**Re: Design Review – Proposed Highschool Orleans Sud – 2405 & 2419
Mer Bleue Road, Ottawa, Ontario
Cambium Reference: 20361-003**

Cambium Inc. (Cambium) was requested to review the current civil and structural drawings for the proposed high school to be located 2405 and 2419 Mer Bleue Road in Ottawa, Ontario.

**GRADING & DRAINAGE  
PLAN**

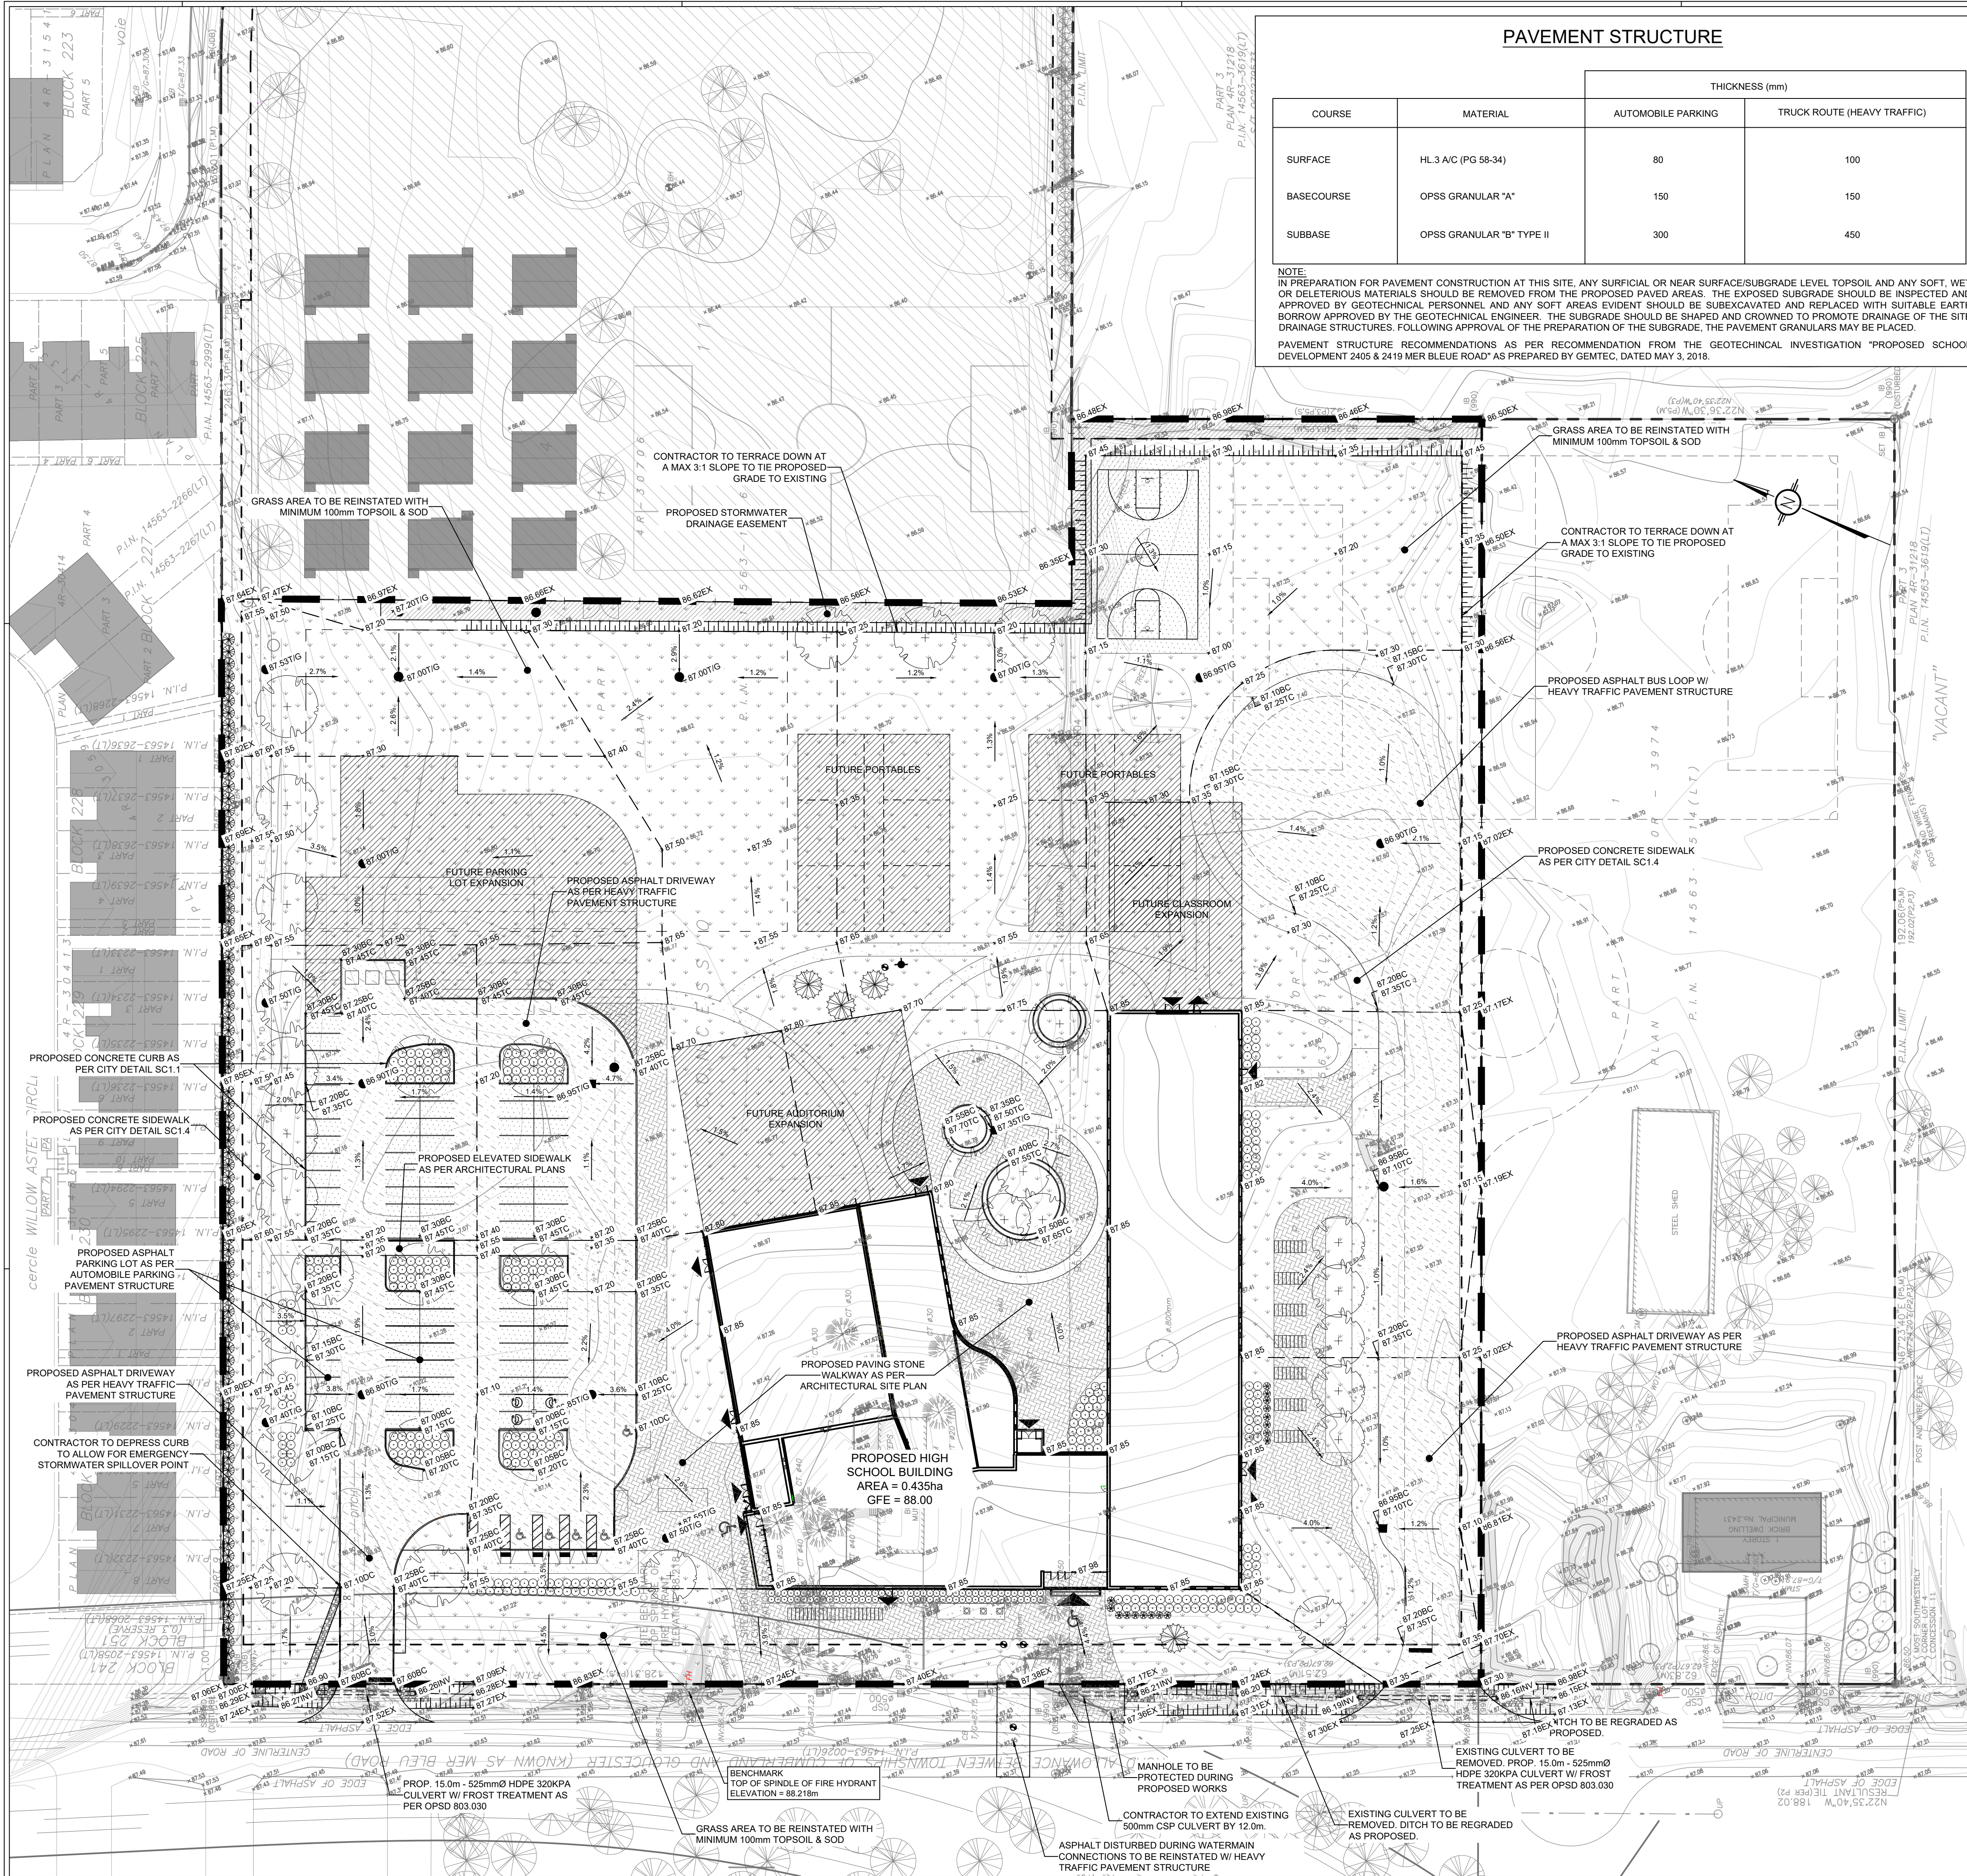
Based on the review, the civil design drawings are in general accordance with the geotechnical report. The proposed site grades are within restriction tolerances outlined. There is a noted exceedance within the parking area at one curb. However this was confirmed through correspondence with the Civil Engineer on September 22, 2025 (via email, Kyle Herold <kherold@lrl.ca>) that the exceedance is a typo. The proposed elevation of the curb was provided and within acceptable grade raise limits of the parking area. It is understood that the typo will be corrected in the next revision of the grading plan.
